## Case ref: 323895

### Ros a' Mhíl

## Fisheries Harbour Centre

## Observer Submission

Drawing file: 2025-11-21 EIAR PLANNING DRAWINGS / 24984-XX-XXX-DR-MWP-CE-5110-0 AREAS TO BE DREDGED.pdf

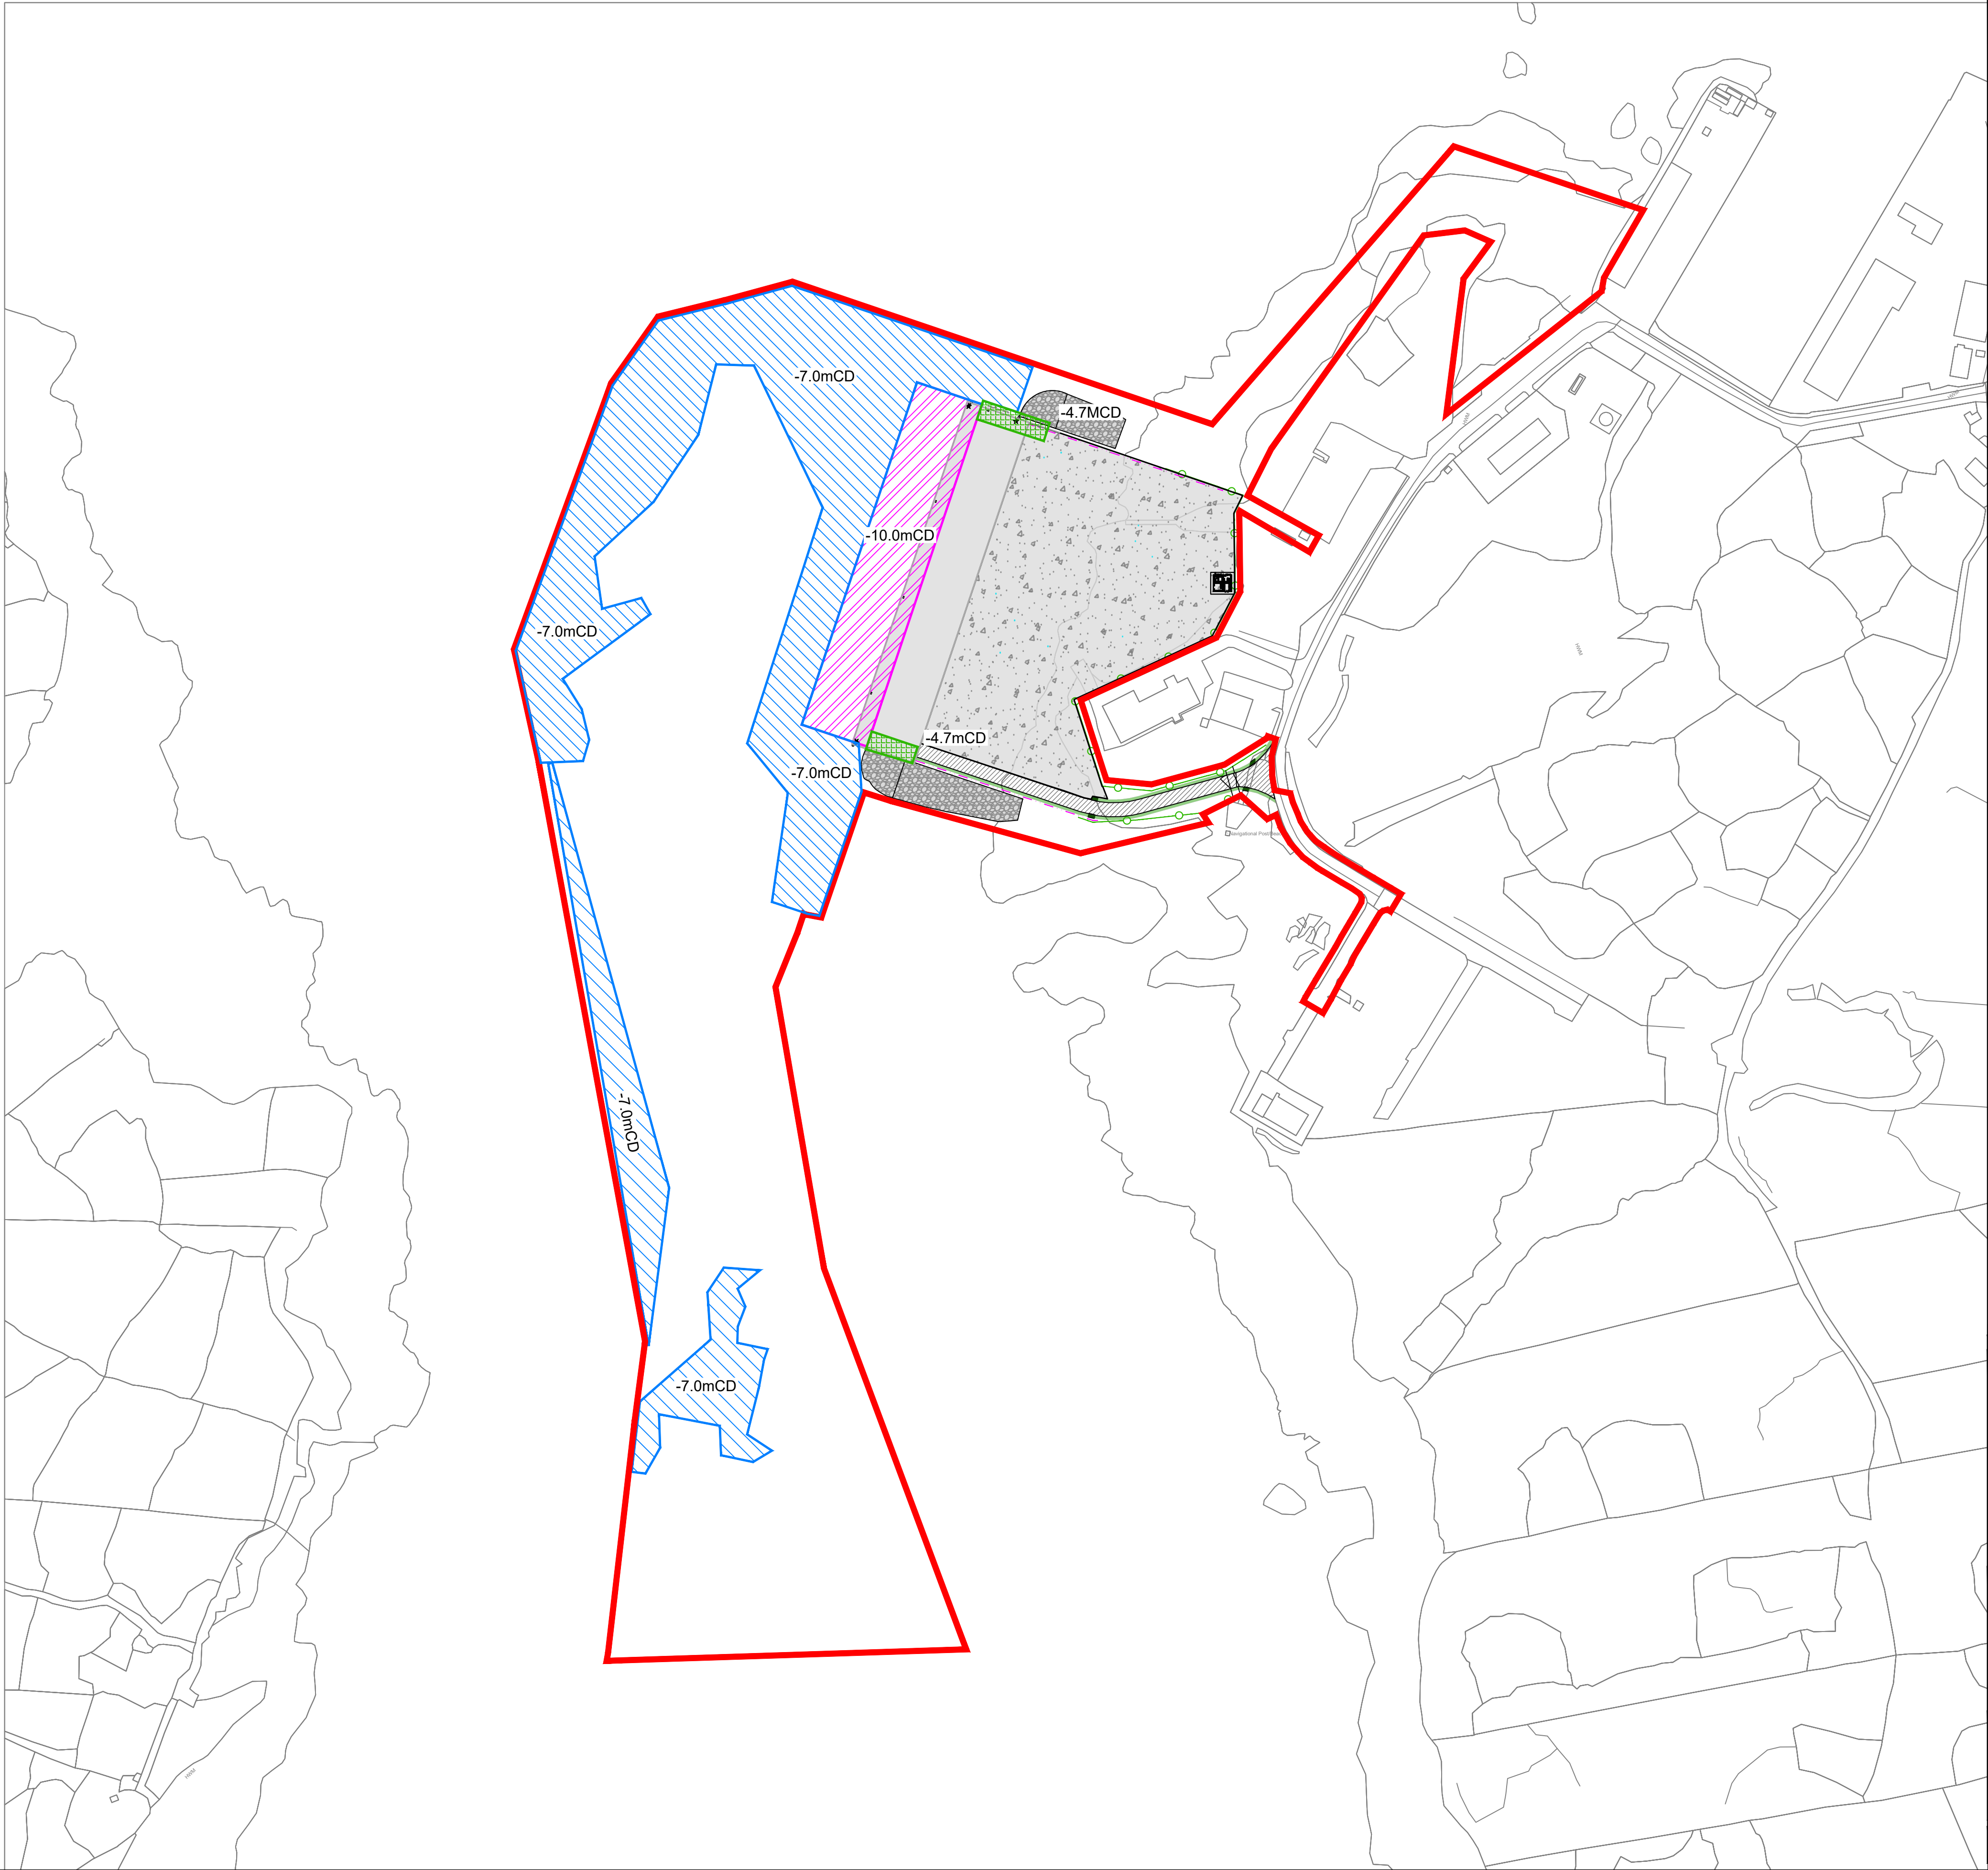
- 5.5 In WID's opinion the treatment of dredging and seabed disturbance is particularly deficient. Chapter 8 of the EIAR and Appendix 8A identify the presence of contaminated sediments, including PCBs, PAHs and heavy metals. However, there is no worst-case assessment of contaminant mobilisation, no robust sediment plume dispersion modelling, no assessment of

- 5.6 The SOCOTEC Laboratory analysis of sediments within the proposed dredging and excavation footprint confirms the presence of multiple toxic and persistent substances, including but not limited to polychlorinated biphenyls (PCBs), polycyclic aromatic hydrocarbons (PAHs), and elevated concentrations of heavy metals. These substances are universally recognised as environmentally hazardous due to their persistence, toxicity and capacity to bioaccumulate. Their identification establishes, as a matter of fact, that the sediments are chemically contaminated and cannot be regarded as inert or benign material.

- 5.7 The significance of these findings is amplified by the nature of the proposed works. The development expressly involves dredging, excavation and, in places, blasting within the very sediments that have been chemically characterised. These activities will inevitably disturb sediment structure, alter redox conditions and resuspend fine particulates, thereby mobilising contaminants that are currently bound within the sediment matrix. Once mobilised, such substances do not remain localised. They enter the water column, are transported by tidal and current-driven processes, and become available for uptake by aquatic organisms well beyond the immediate works area.

- 5.9 No assessment is carried out of contaminant mobilisation during dredging, no modelling of sediment plume chemistry or dispersion is provided, and no evaluation is undertaken of indirect discharges of hazardous substances to the marine environment. The EIAR therefore fails to assess a foreseeable and intrinsic effect of the project. In environmental law terms, this is not a matter of disagreement between experts or of mitigation design; it is a failure to assess an effect
